CITY OF MERCER ISLAND

May 18, 2018

RE: CAO17-007 (Critical Area Determination for 4634 E Mercer Way) May 9, 2018 Resubmittal

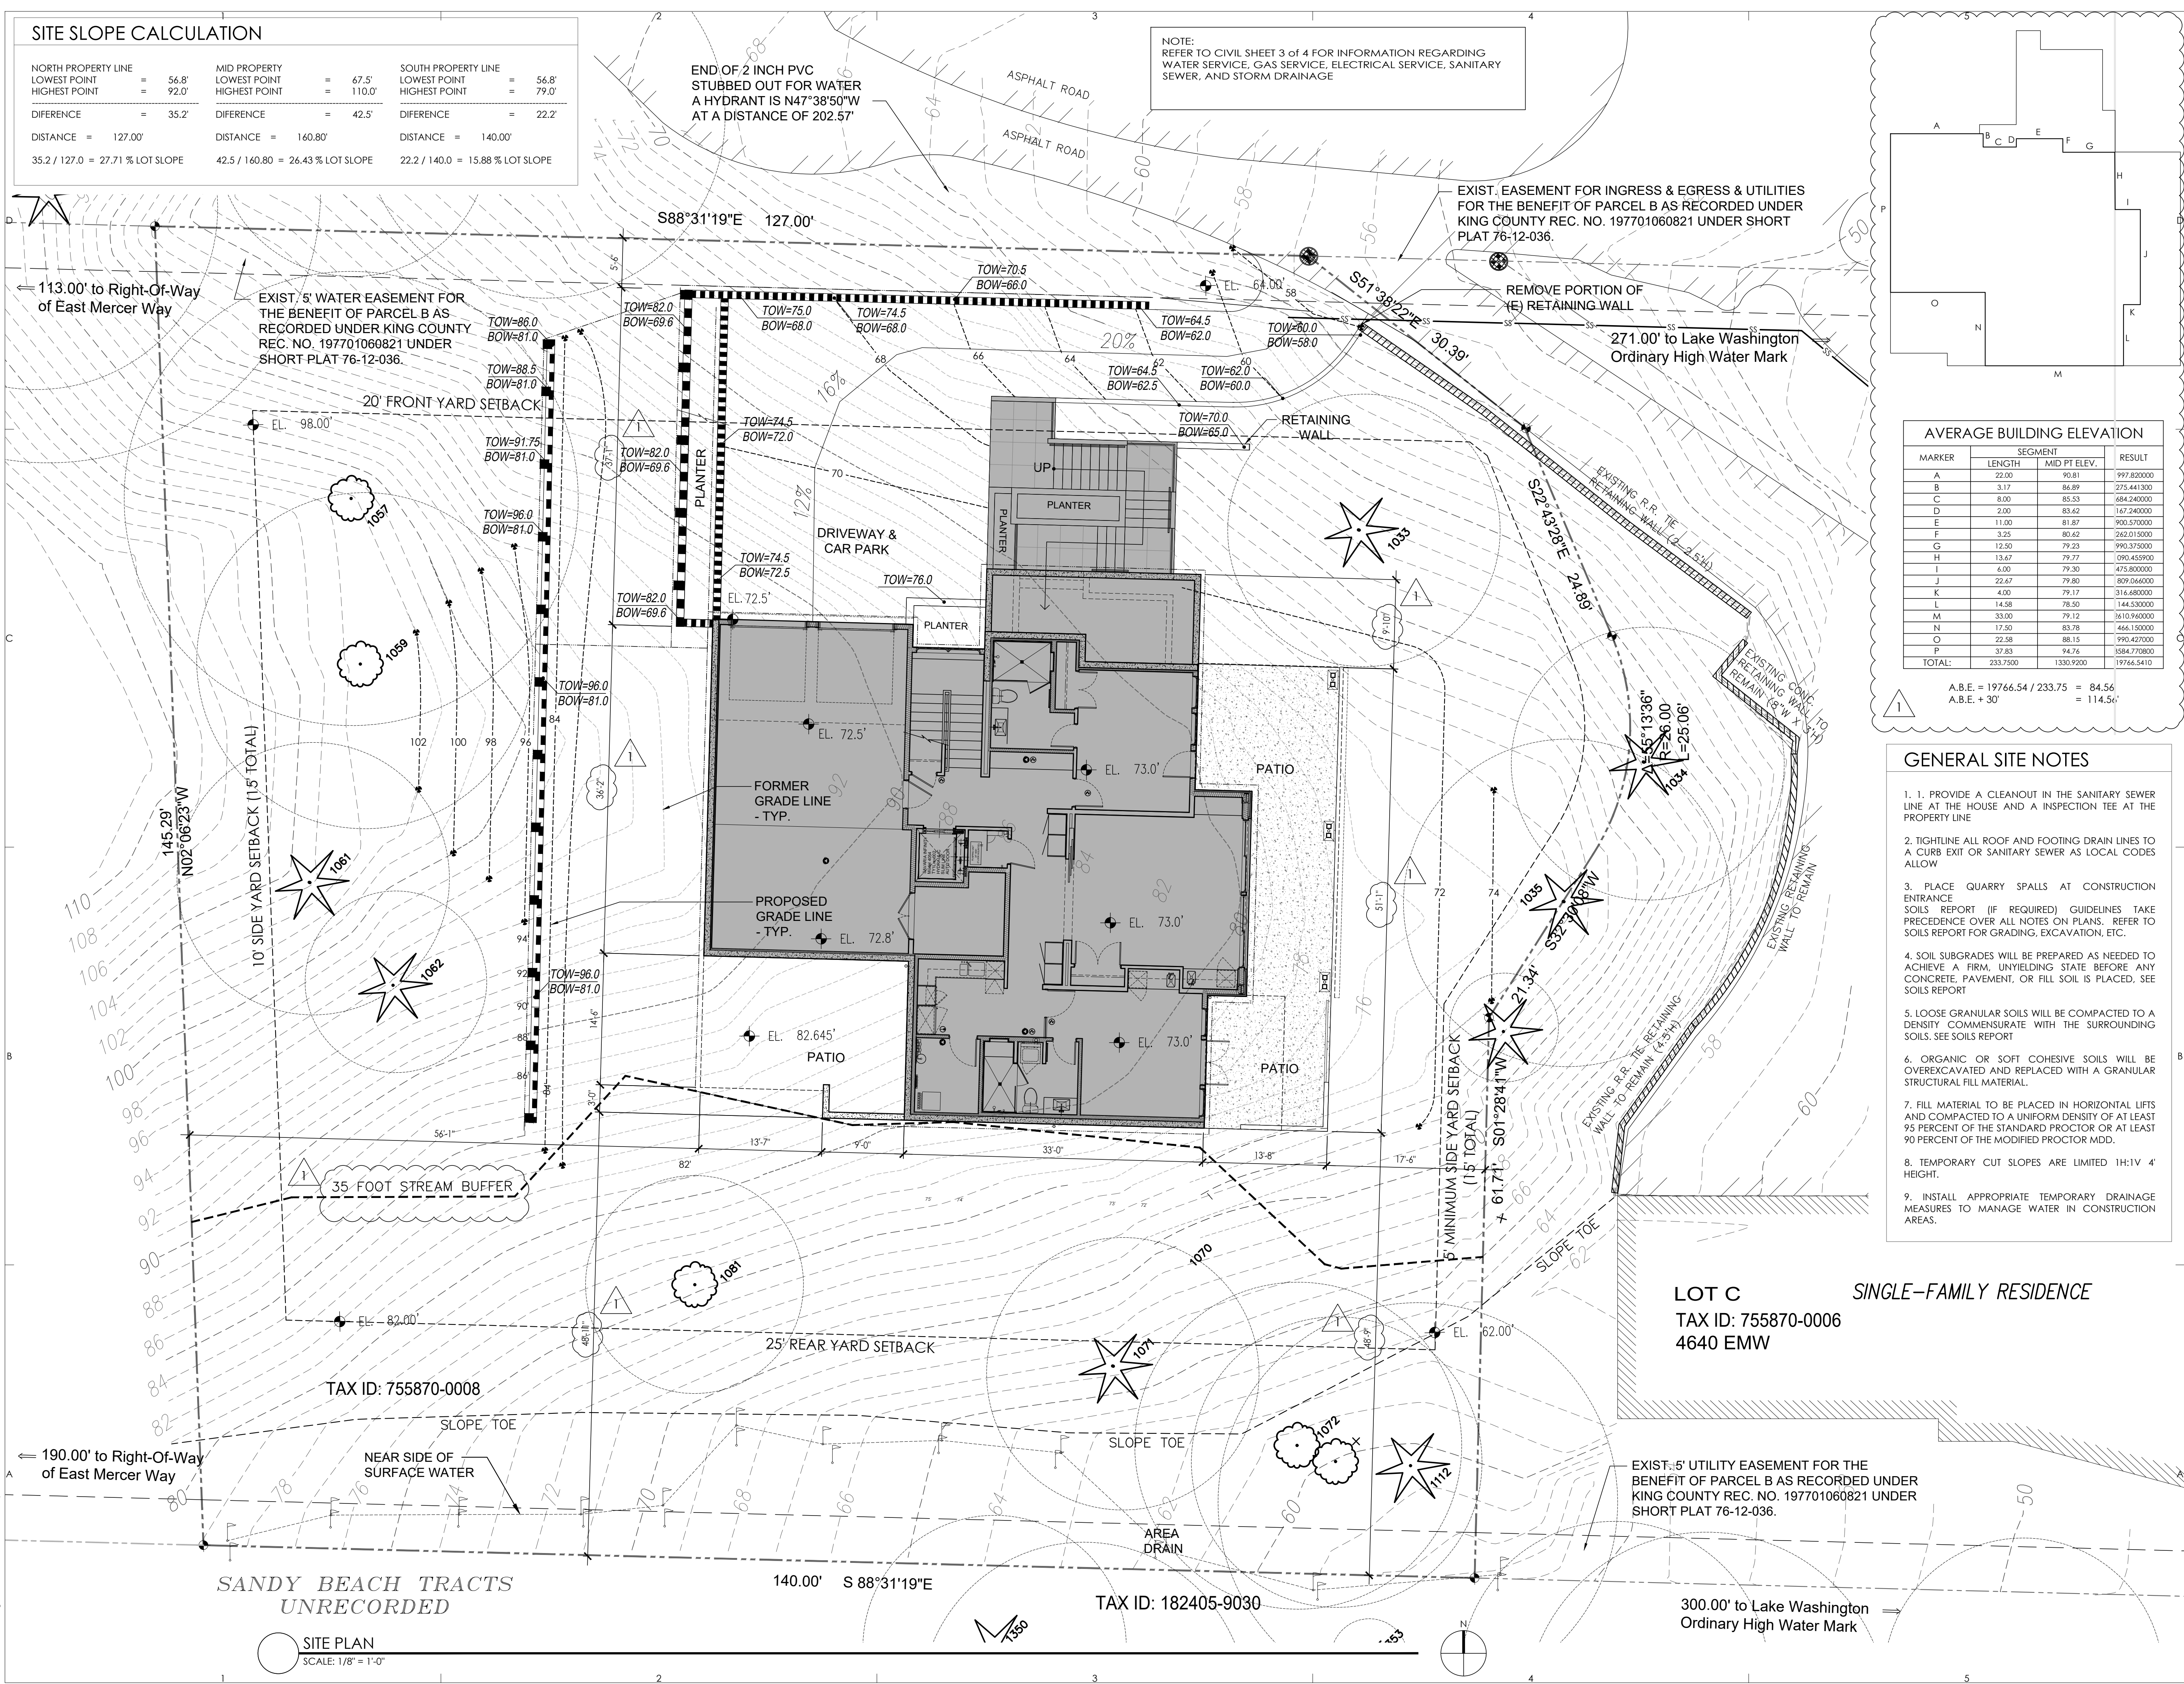
1. Item 2.b. from the October 26, 2017 correction letter requests that either the proposed design be modified to avoid work within the watercourse buffer, or that a critical areas study be provided that addresses the proposed work within the watercourse buffer. Sheet A1.02 shows a storm drain within the buffer for the Type 2 watercourse, and no critical areas study addressing this impact has been submitted, leaving this item unaddressed.
